WEST SUSSEX COUNTY COUNCIL CONSULTATION

TO:	Arun District Council FAO: Andrew wood
FROM:	Highways, WSCC
DATE:	10/05/2018
LOCATION:	Flat 1, 126, Arundel Road, Littlehampton, BN17 7DW
SUBJECT:	LU/92/18/PL Studio apartment with roof extensions & bin store & cycle store
DATE OF SITE VISIT:	n/a
RECOMMENDATION:	
S106 CONTRIBUTION TOTAL:	n/a

This application seeks a proposed studio apartment with roof extensions & bin store & cycle store at 126, Arundel Road, Littlehampton. 126 Arundel Road, Littlehampton currently provides 3 x 1 bedroom flats. The proposed seeks to create a studio apartment on a new second floor.

PROPOSED CYCLE & BIN STORE  
DETAILS

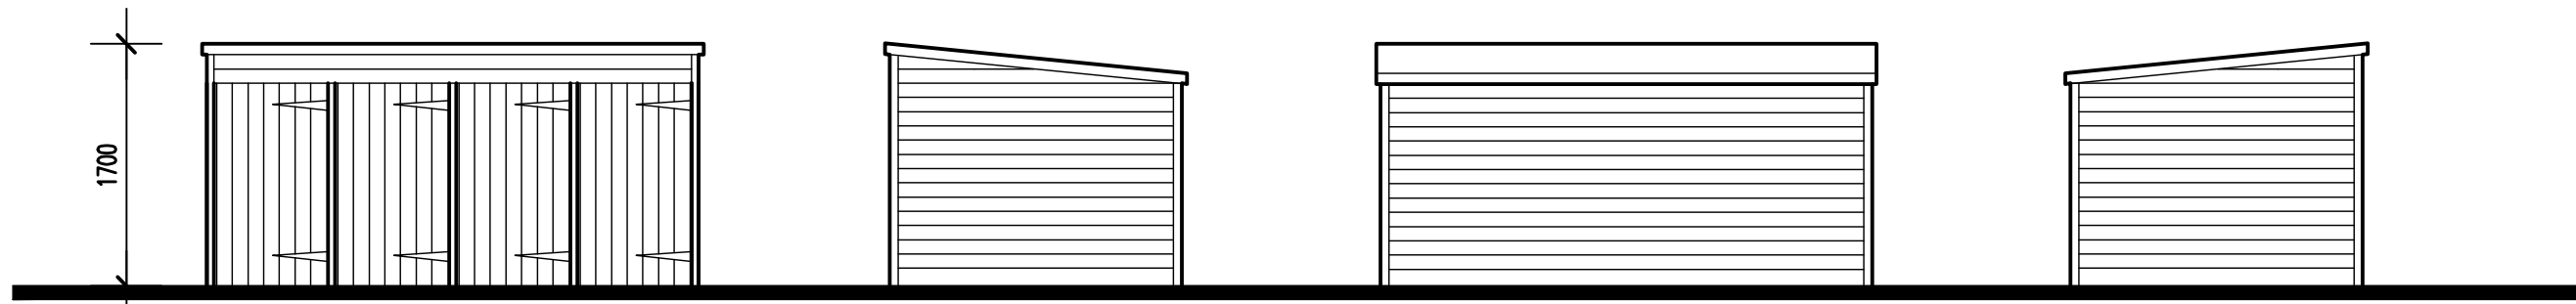
A communal cycle parking facility large enough to park 4 cycles will be provided. This would be considered an adequate

Cycle parking

No part of the development shall be first occupied until covered and secure cycle parking spaces have been provided in accordance with the approved plans.

BLOCK PLAN
Scale 1:200

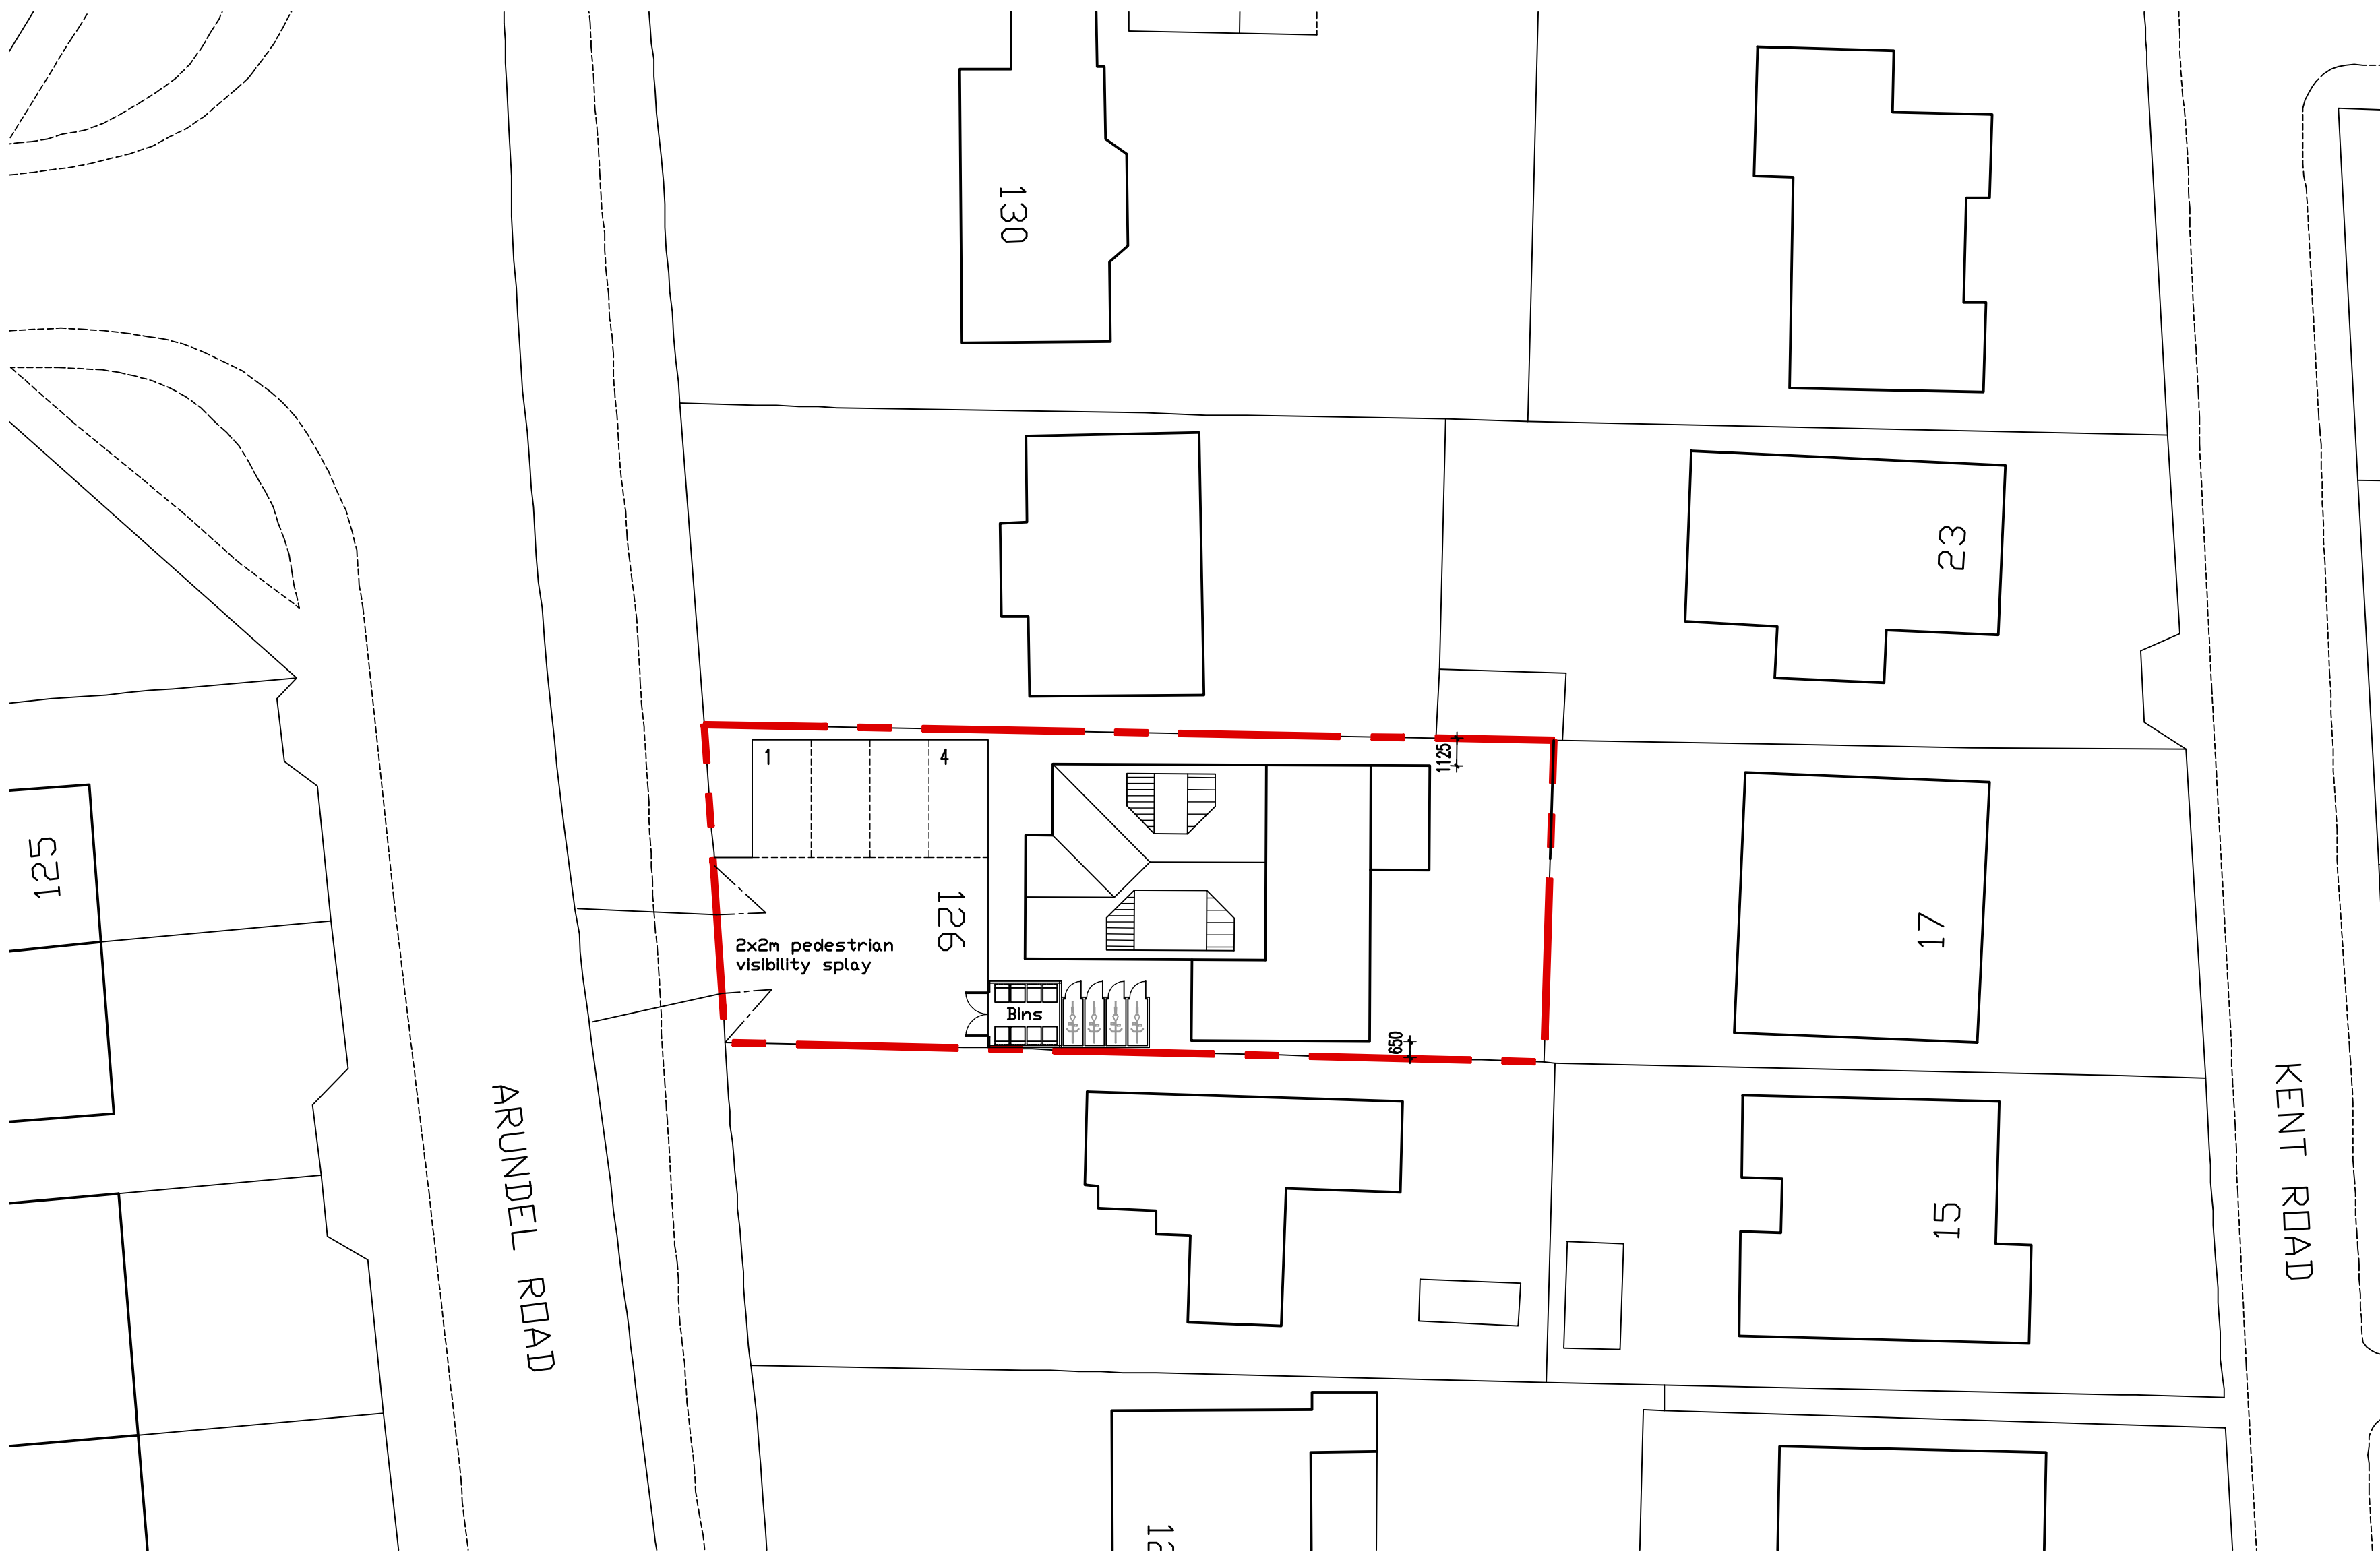
No changes are to be made to the existing access arrangements, though the block plan does demonstrate 2 x 2 pedestrian visibility splays.

Pedestrian Visibility

No part of the development shall be first occupied until pedestrian visibility splays of 2 metres by 2 metres have been provided either side of the existing site vehicular access onto Arundel Road in accordance with the approved plans. These visibility splays shall thereafter be kept free of all obstructions over a height of 0.6 metre above adjoining carriageway level or as otherwise agreed.

The resultant 4 flats will be provided with 4 car parking spaces. These spaces seem to be an existing provision. It is not clear if these will be allocated or unallocated. The Local Highways Authority would advise they are unallocated to be used on a flexible basis by all residents. Given the sustainable location the proposed quantity of car parking provision would be considered adequate regardless allocation.

Car parking space

No part of the development shall be first occupied until the car parking has been constructed in accordance with the approved site plan. These spaces shall thereafter be retained at all times for their designated purpose.
